**DEVELOPMENT REVIEW BOARD  
ACTION SHEET**

33 **Project #: 1003428**  
04DRB-00716 Minor-SiteDev:Plan  
BldPermit

JOHN K. KLEE agent(s) for INTERSTATE DEVELOPMENT LLC request(s) the above action(s) for all or a portion of Lot(s) 54, **ALAMEDA BUSINESS PARK**, zoned SU-2 IP-EP, located on PASEO ALAMEDA NE and VISTA ALAMEDA NE, containing approximately 1 acre(s). [REF: DRB-98-223, 1000624 (Master Plan)] (Deferred from 5-19-04) (C-16) **THE SITE PLAN FOR BUILDING PERMIT WAS APPROVED WITH FINAL SIGN-OFF-DELEGATED TO PLANNING AND TRANSPORTATION FOR PART OF A 6-FOOT LANDSCAPE BUFFER ON THE EAST SIDE, SOLID WASTE'S SIGNATURE, RADIUS AT ENTRANCE TO BE 15 FEET, AND STANDARD NOTE FOR CONSTRUCTION OF DRIVE PAD.**

RE: Lot 54, Alameda Business Park/SPBP

SHEET TITLE: SITE PLAN DEVELOPMENT PLAN FOR BUILDING PERMIT

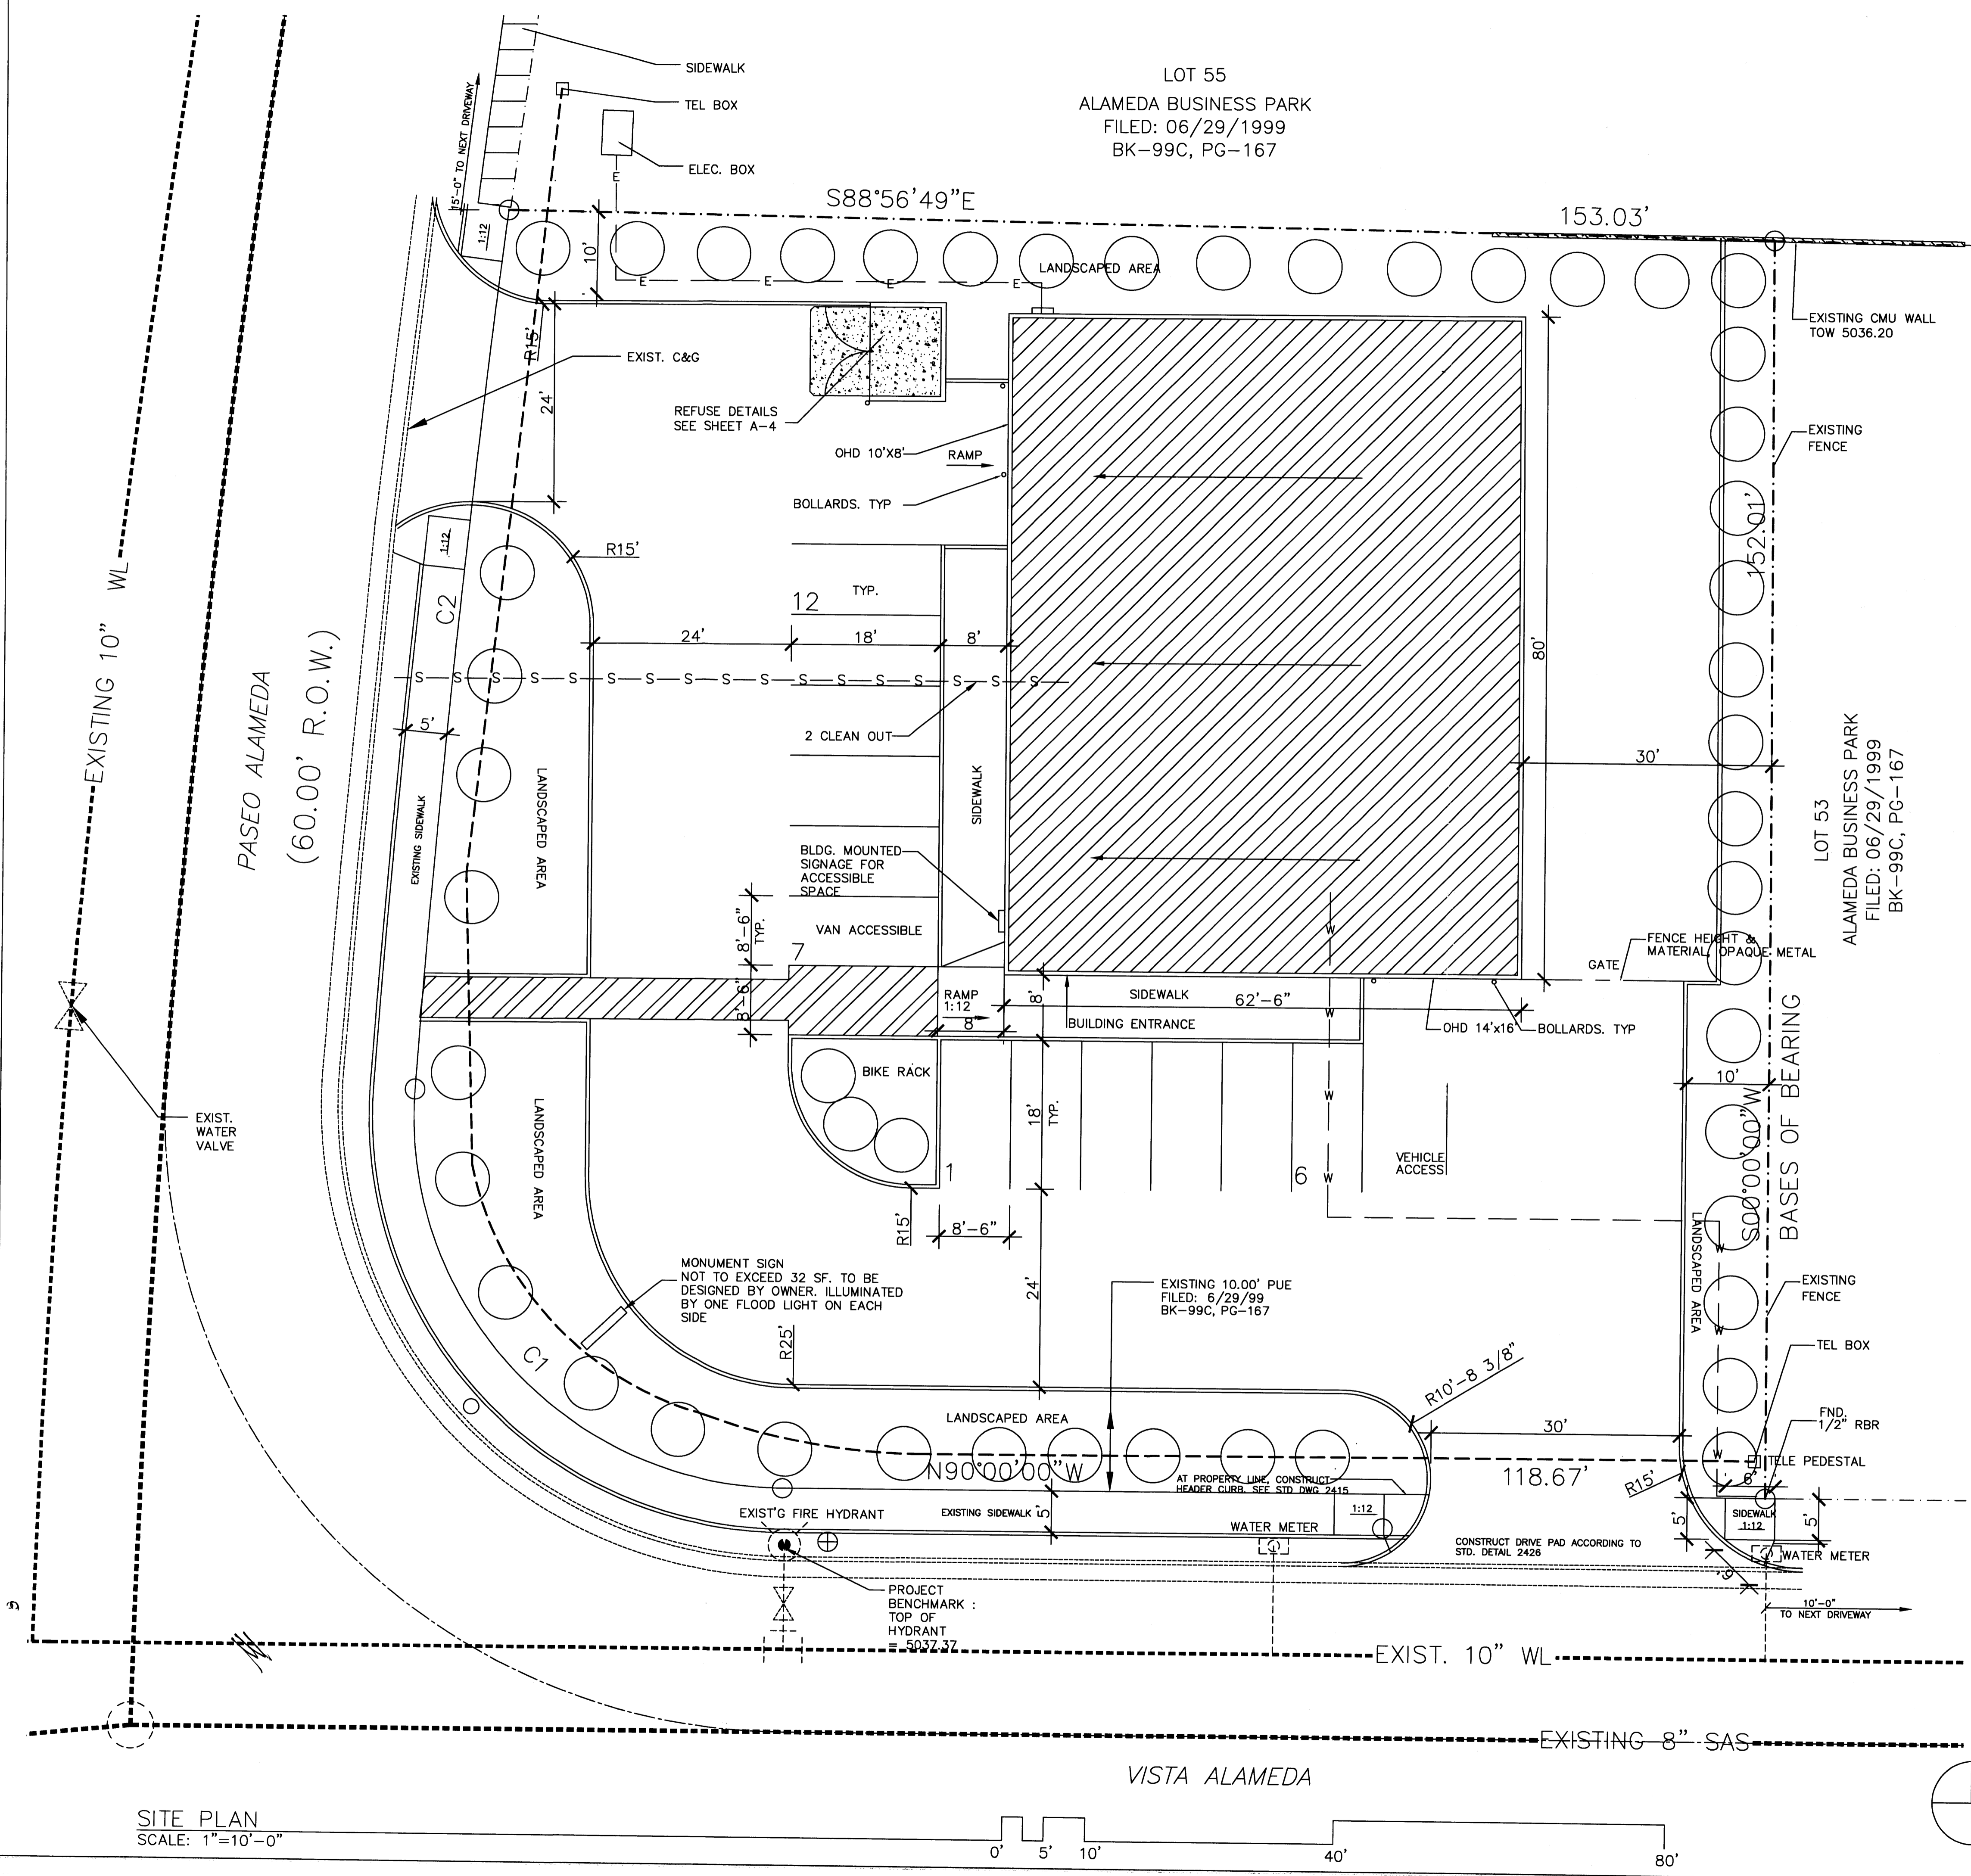
1. Please flip the signature block and the Design Data on the site plan sheet so that the signature block is on the right. Then remove the fax information from the top of the signature block. Each sheet in the site plan package should be consecutively numbered (Landscape Plan)

✓ 2. The site plan sheet should be re-titled "Site Development Plan for Building Permit".

3. The scale on the site plan & landscape plan should be 1" = 10'.

4. The property line should be bolded so that it is clearly identifiable.

5. Are there to be any walls or fences on the sides abutting either street? If so, they require perimeter wall design approval.

6. The monument sign indicated on the site plan should have a dimensioned elevation to scale indicating lighting, if any, and materials & colors for sign face & structural elements.

9. Is there a loading dock?

10. The bike rack...is it on the site plan?

11. How does one drive to the garage door shown on the north side? It appears to abut the landscaping buffer.

NORTH ELEVATION

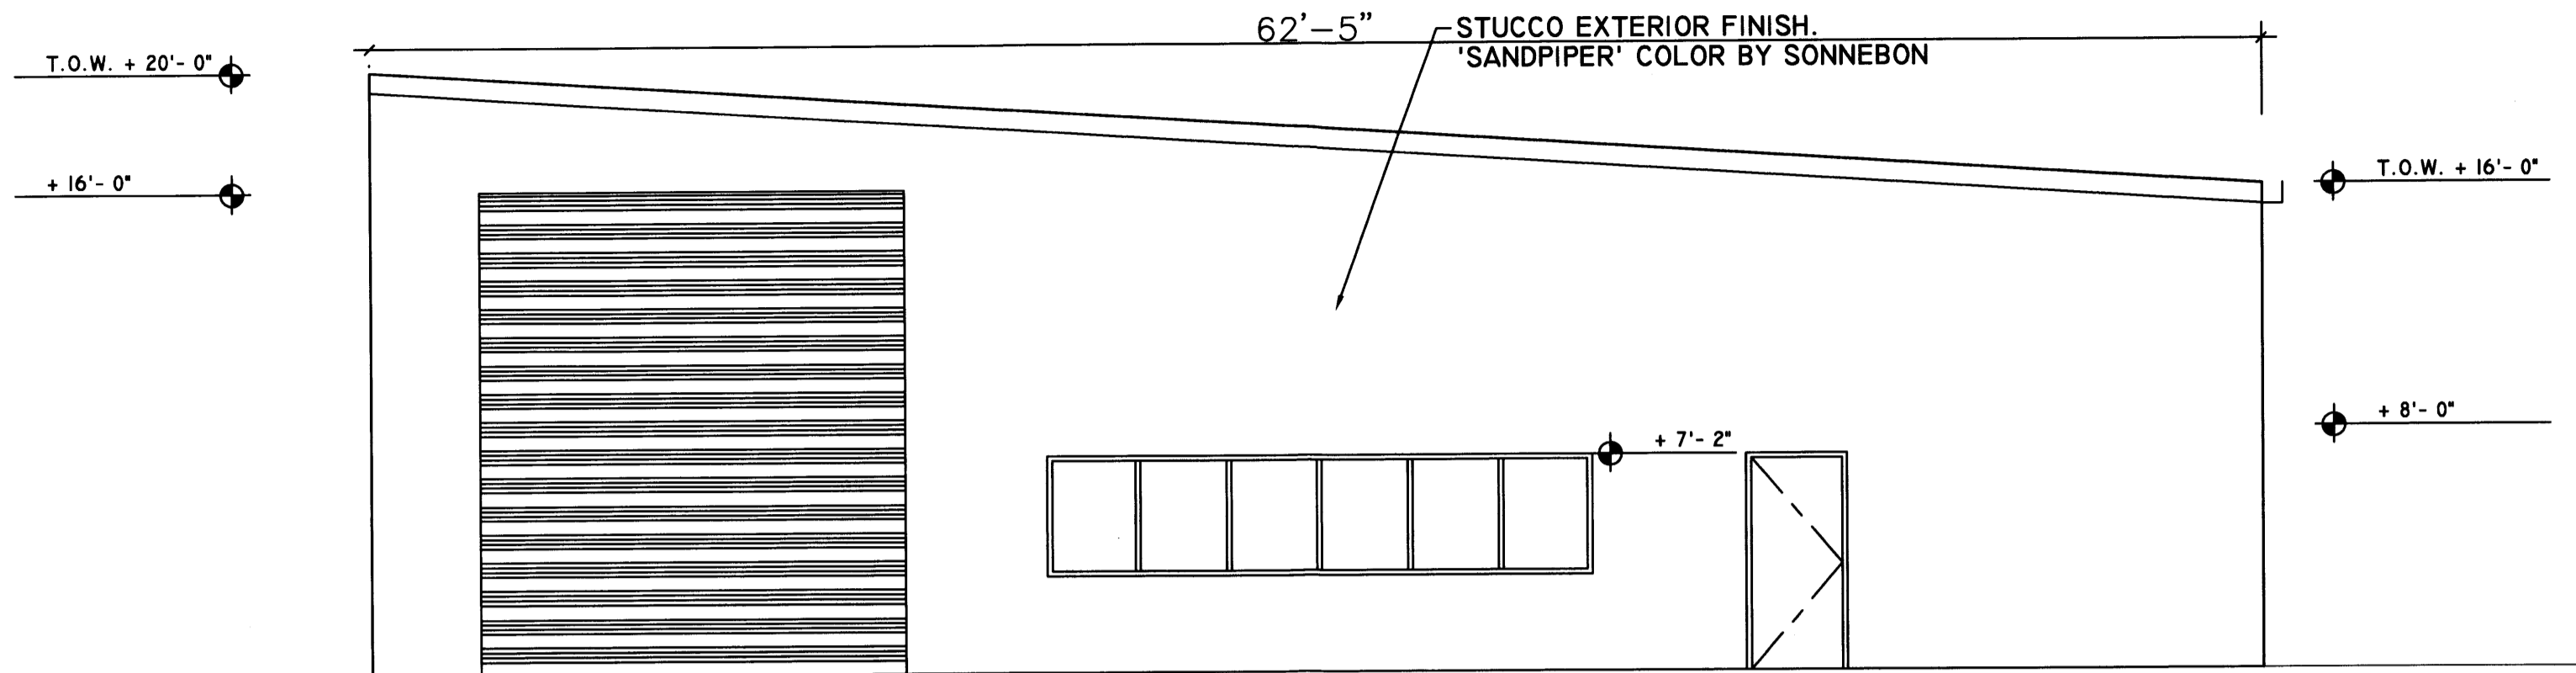
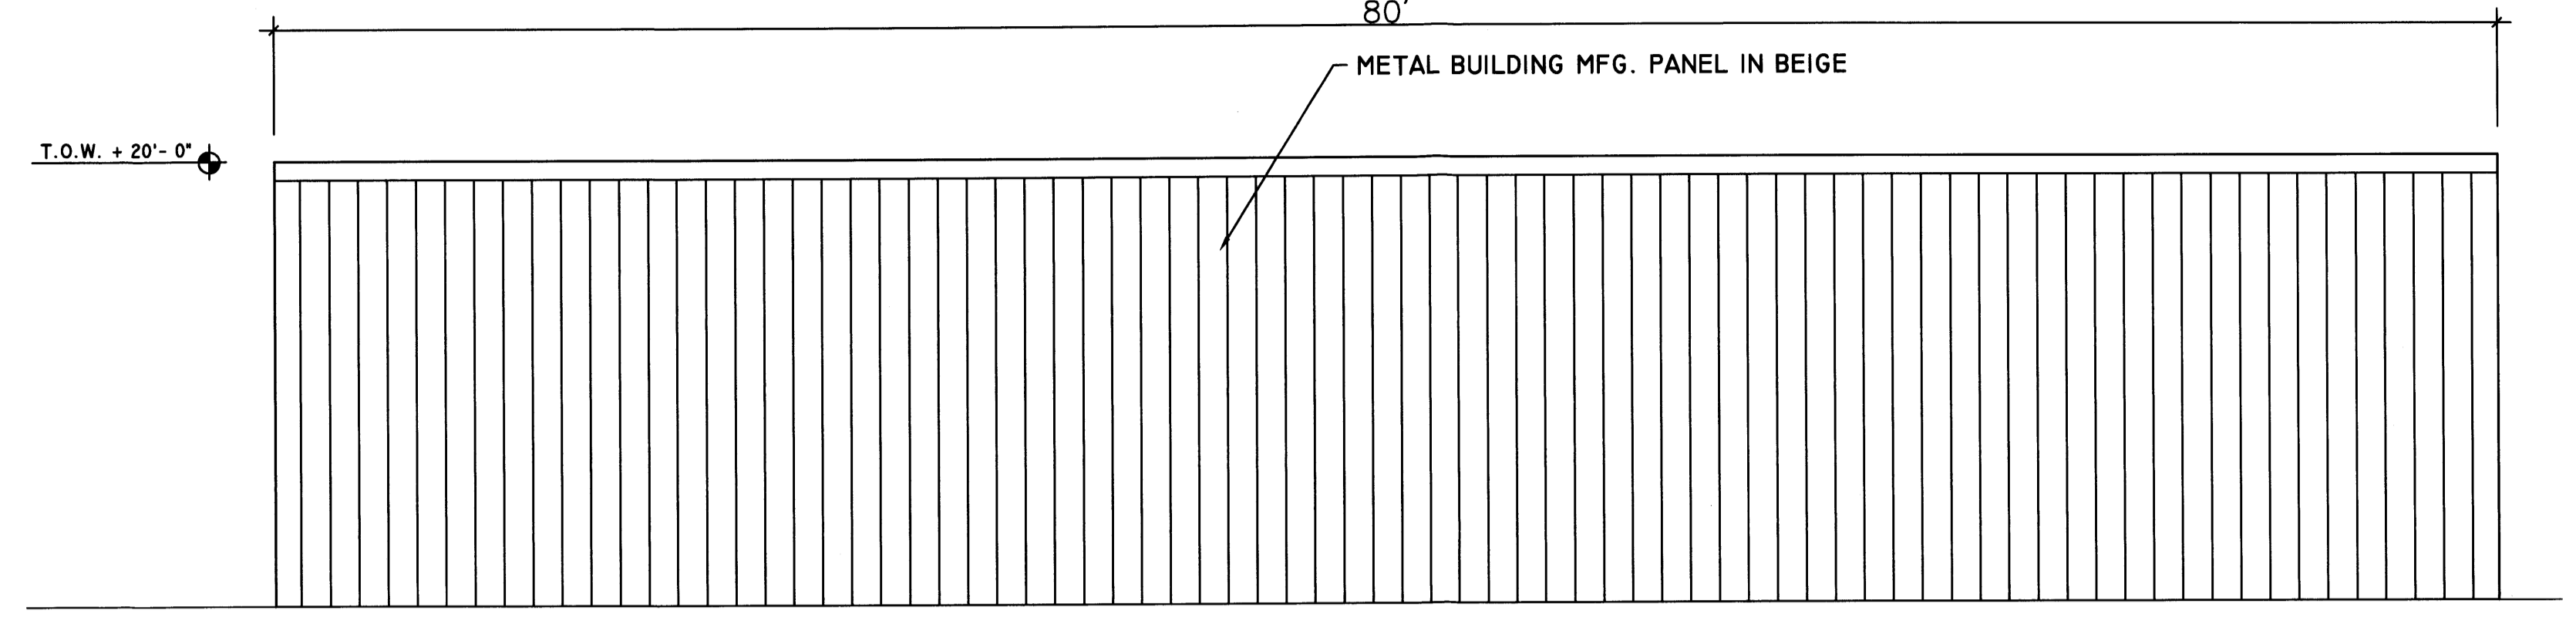
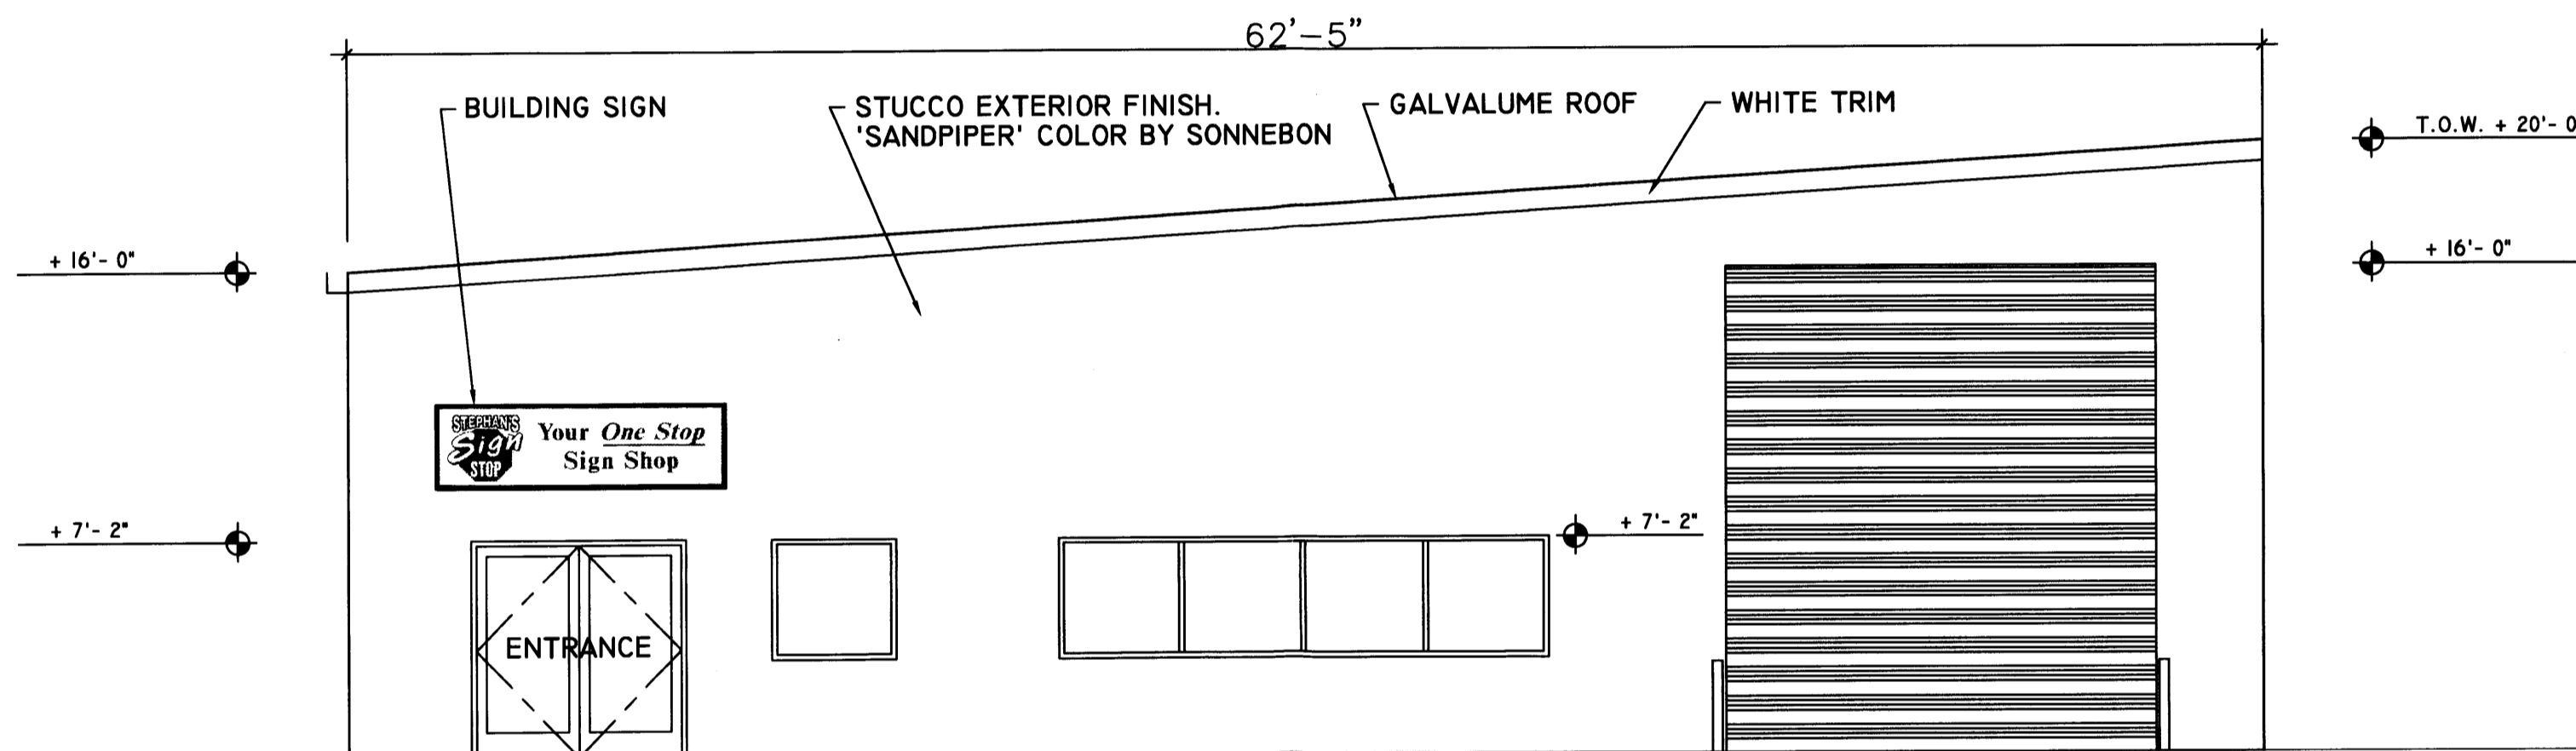
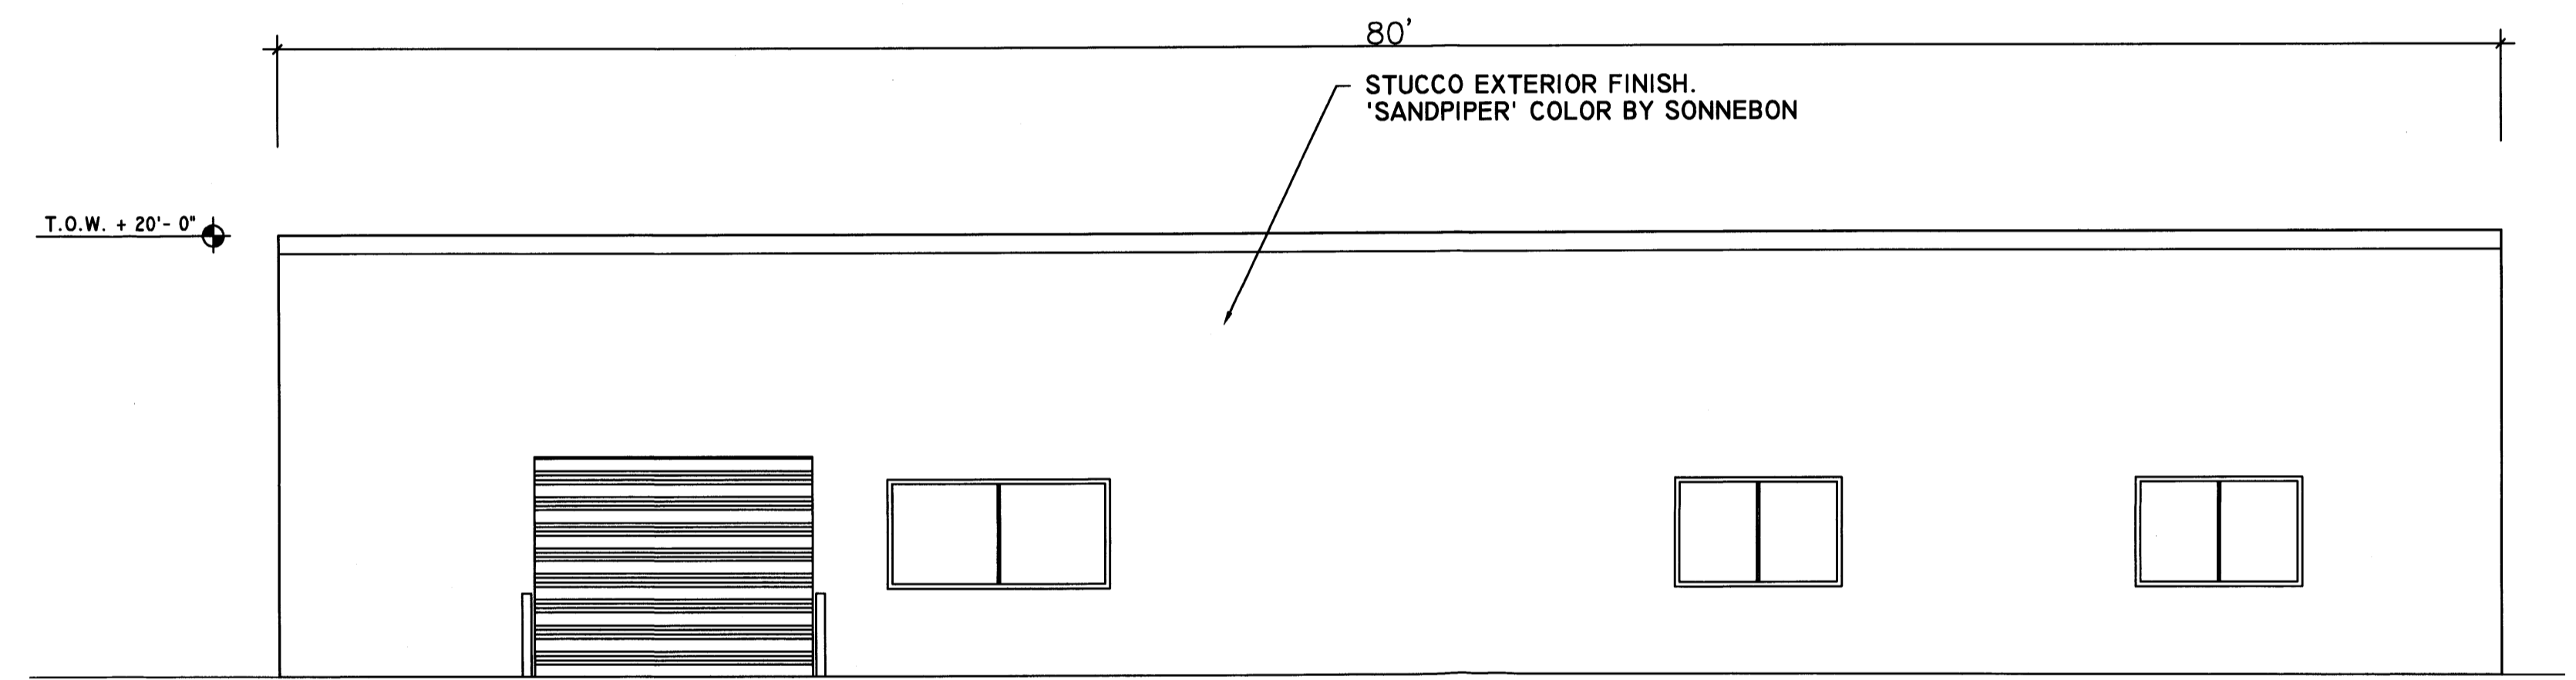
7. Is there any signage planned for the building? If so, the same information is required.
